West Yorkshire Police
Kirklees District

Designing Out Crime Officer

To: William Simcock Kirklees Council Planning Services	Ref: 2023/90793 Date: 4th May 2023
---	---

Site Location: Technology House, Dyson Wood Way, Bradley, Huddersfield, HD2 1GN
Application: Change of use from commercial to Learning Institution

Site Plan 1:250

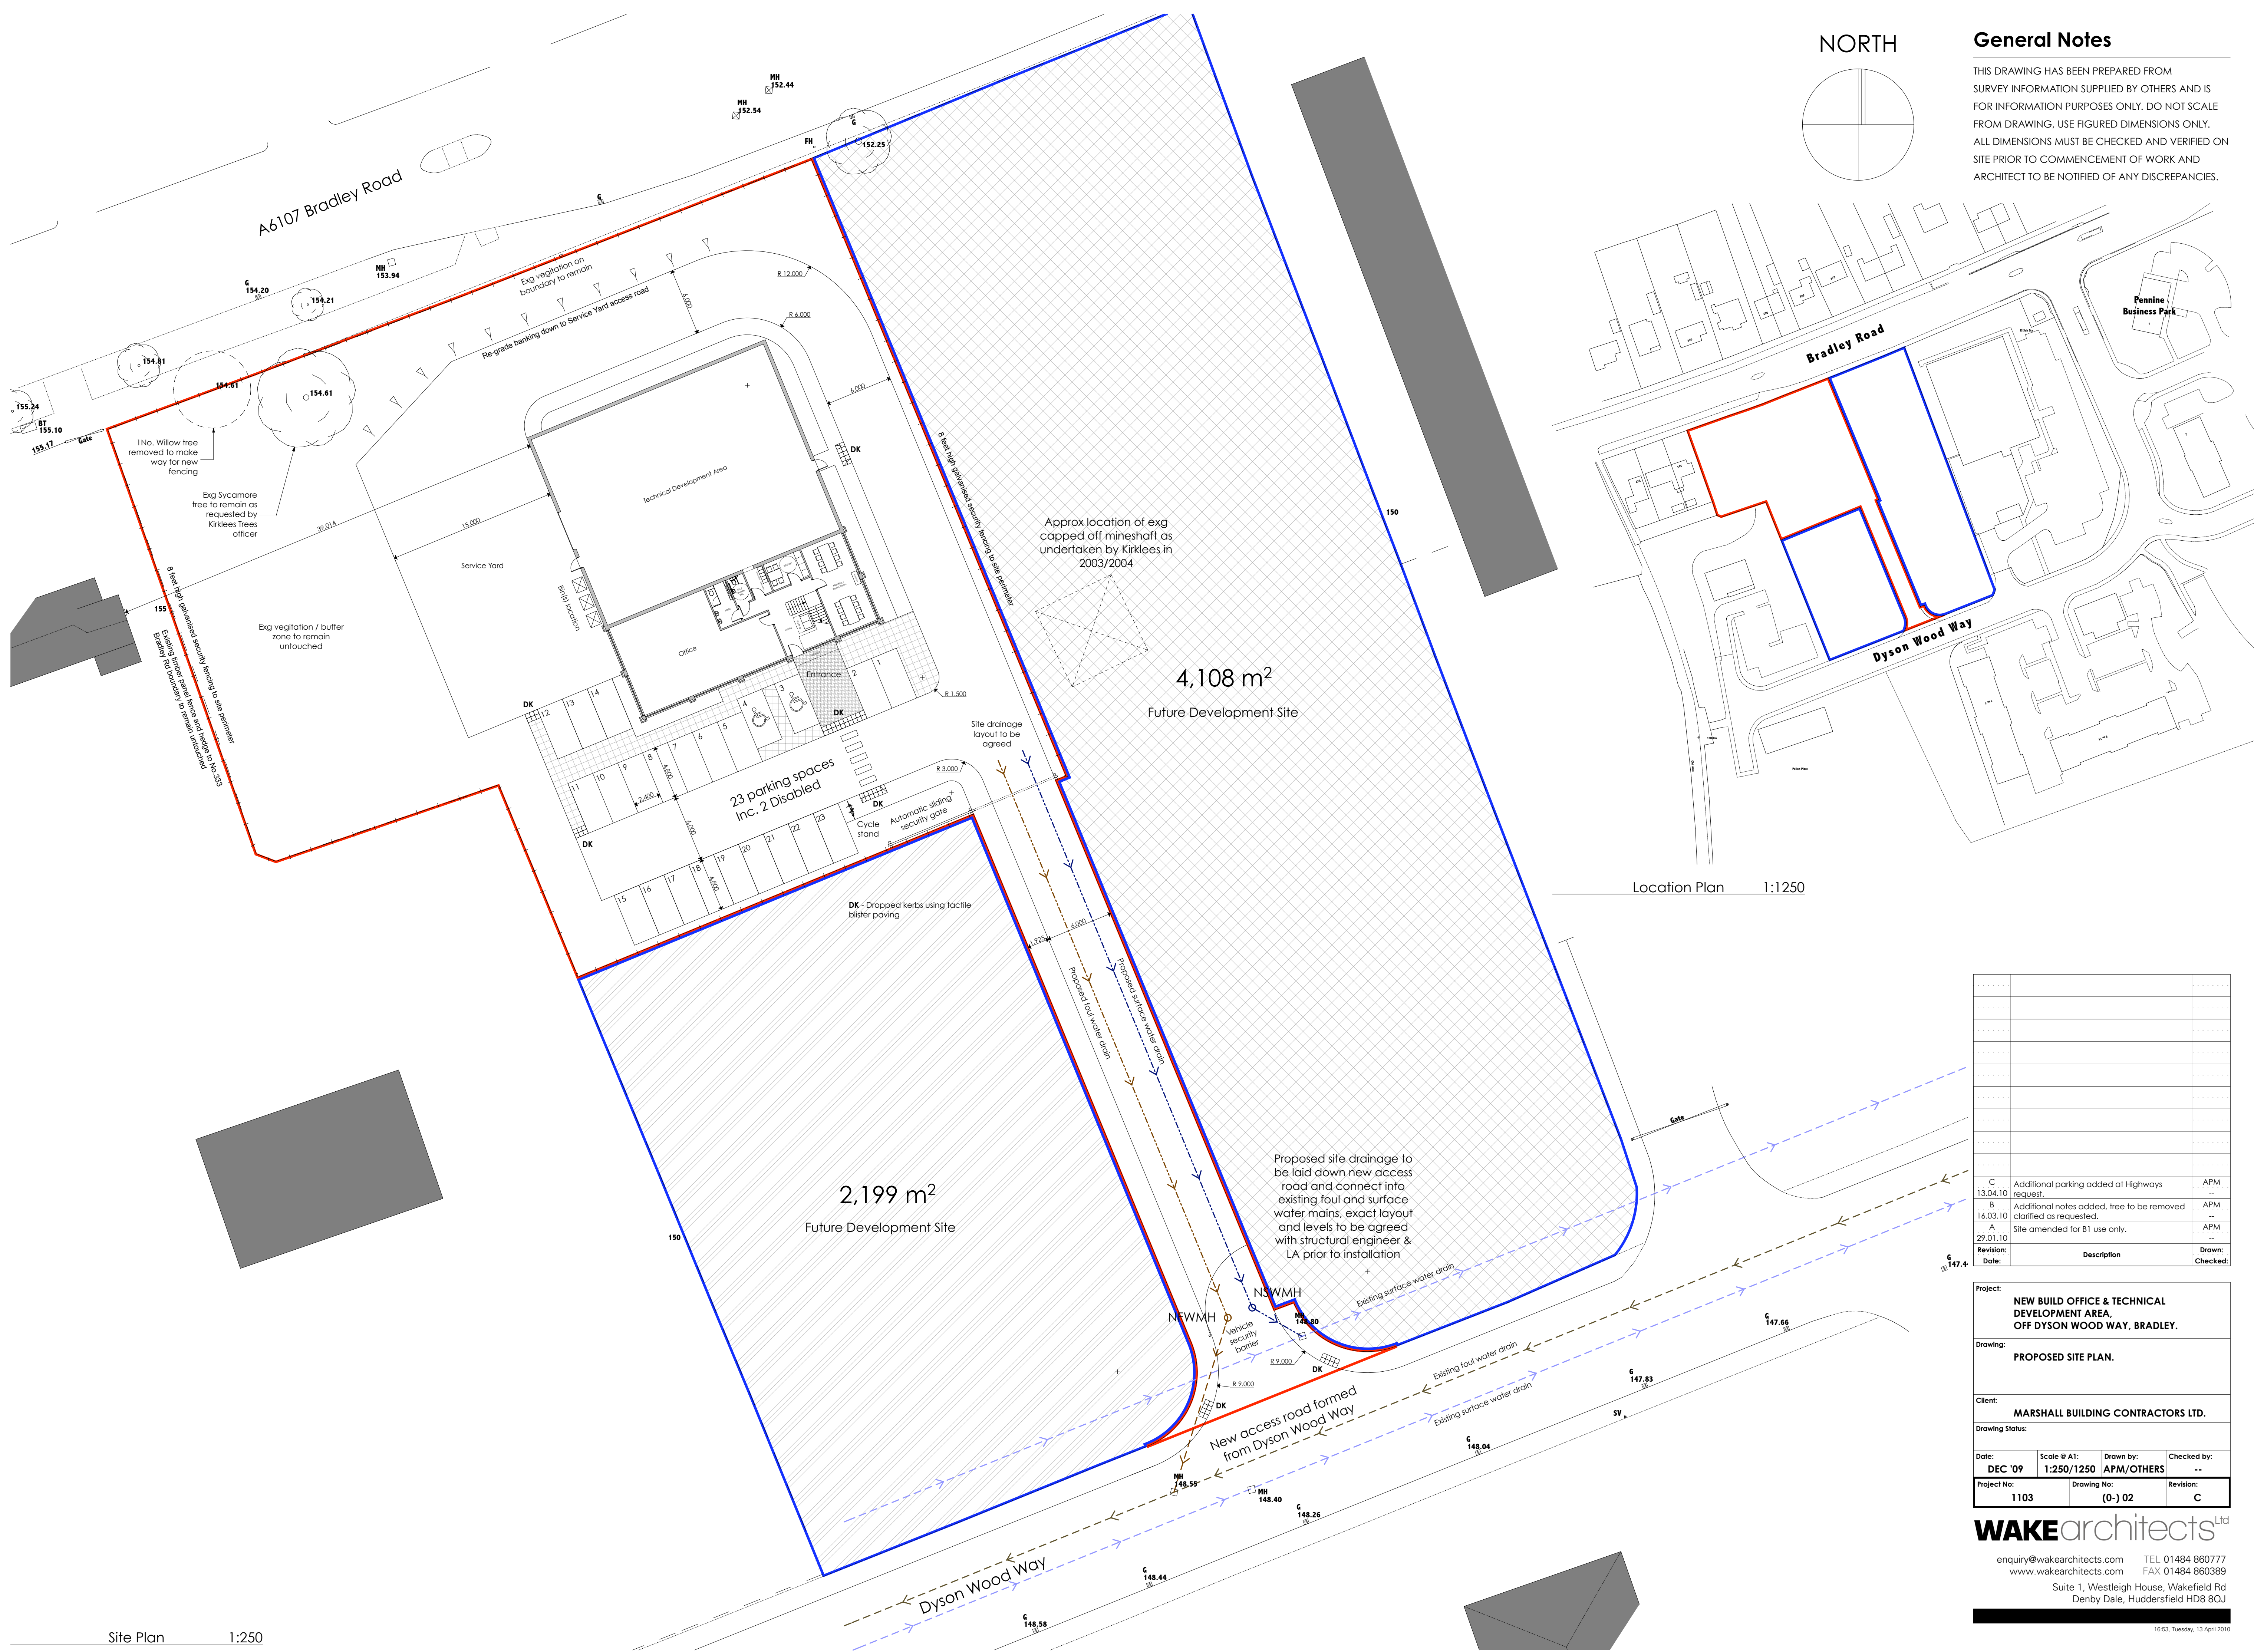
- **Boundary Treatments** – Details are required into the proposed boundary treatments for this site in order to prevent unauthorised access to site users.

- **Access Control** – What are the proposals for access control into the building to prevent unauthorised access?
- **CCTV and Lighting measures** – Could the applicants please supply details of CCTV and lighting for this site to help with crime prevention and detection.

- **Plant & Store Rooms** – All the plant and store rooms must be made secure with either an access control system or appropriate locks to prevent unauthorised entry.
